Ribble Valley Borough Council
Development Control

Your ref 3/2020/0309
Our ref
Date 19th May 2020

Application no: 3/2020/0309
Address: Spout Farm, Longridge
Proposal: Erection 34 dwellings

DRAWING TITLE:  
**PROPOSED SITE ACCESS ARRANGEMENT**

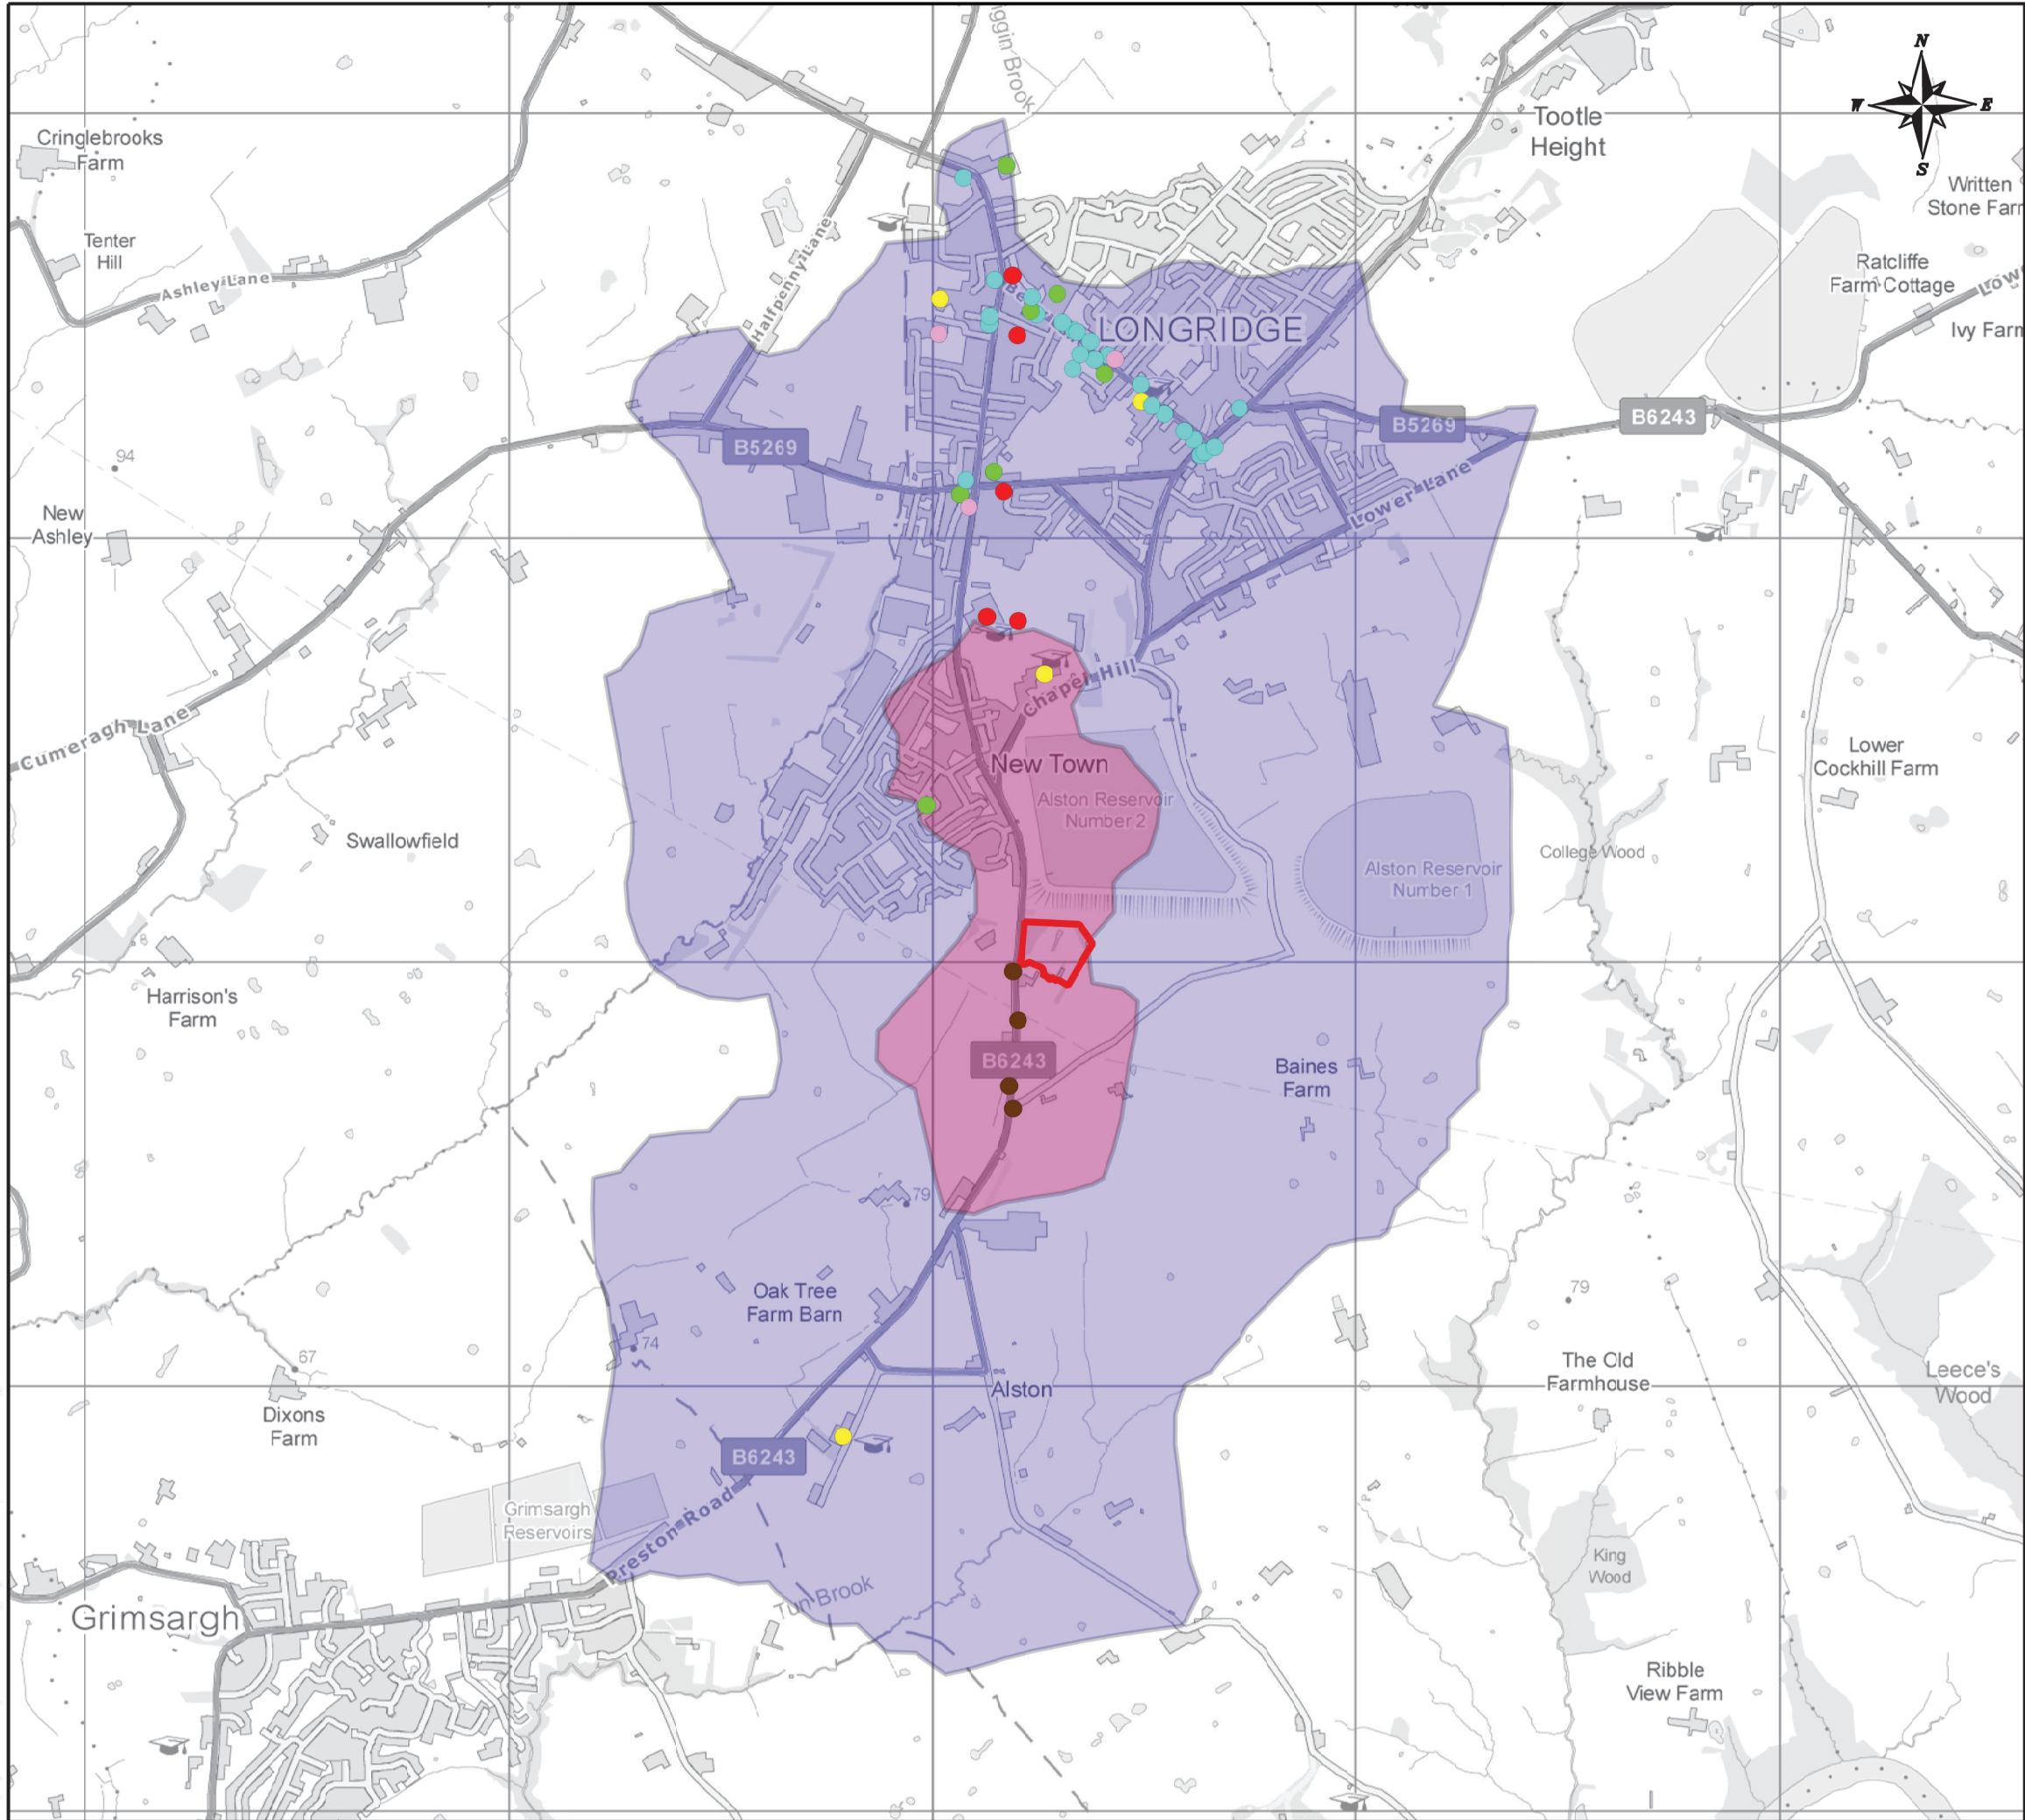
The current application differs from the previously approval in a number of ways most notably in respect of the site layout. The current application layout has been the subject of pre-application discussions with the applicant and a number of amendments have been agreed. Previously there was a desire to create a pedestrian route in the North West corner of the site and provide a new bus stop. However, as a planning requirement of the nearby Keir housing development a new bus stop and shelter has been installed south of the current application site. It is therefore proposed to utilise this stop for the residents of this development and the applicant has proposed, with the agreement of the highway authority, to construct a footway along the grass verge on the easterly side of Preston Road linking the site to the new bus stop.

It is understood from the pre-application discussions that it is the intention of the applicant for the estate roads to be adopted by the highway authority in the absence at this stage, of the appropriate s38 drawing for approval some minor

amendments may be required in order to comply with the highway authority requirements.

4 No part of the development hereby approved shall commence until a scheme for the construction of the site access and the off-site works of highway improvement has been submitted to, and approved by, the Local Planning Authority in consultation with the Highway Authority. Reason: In order to satisfy the Local Planning Authority and Highway Authority that the final details of the highway scheme/works are acceptable before work commences on site.
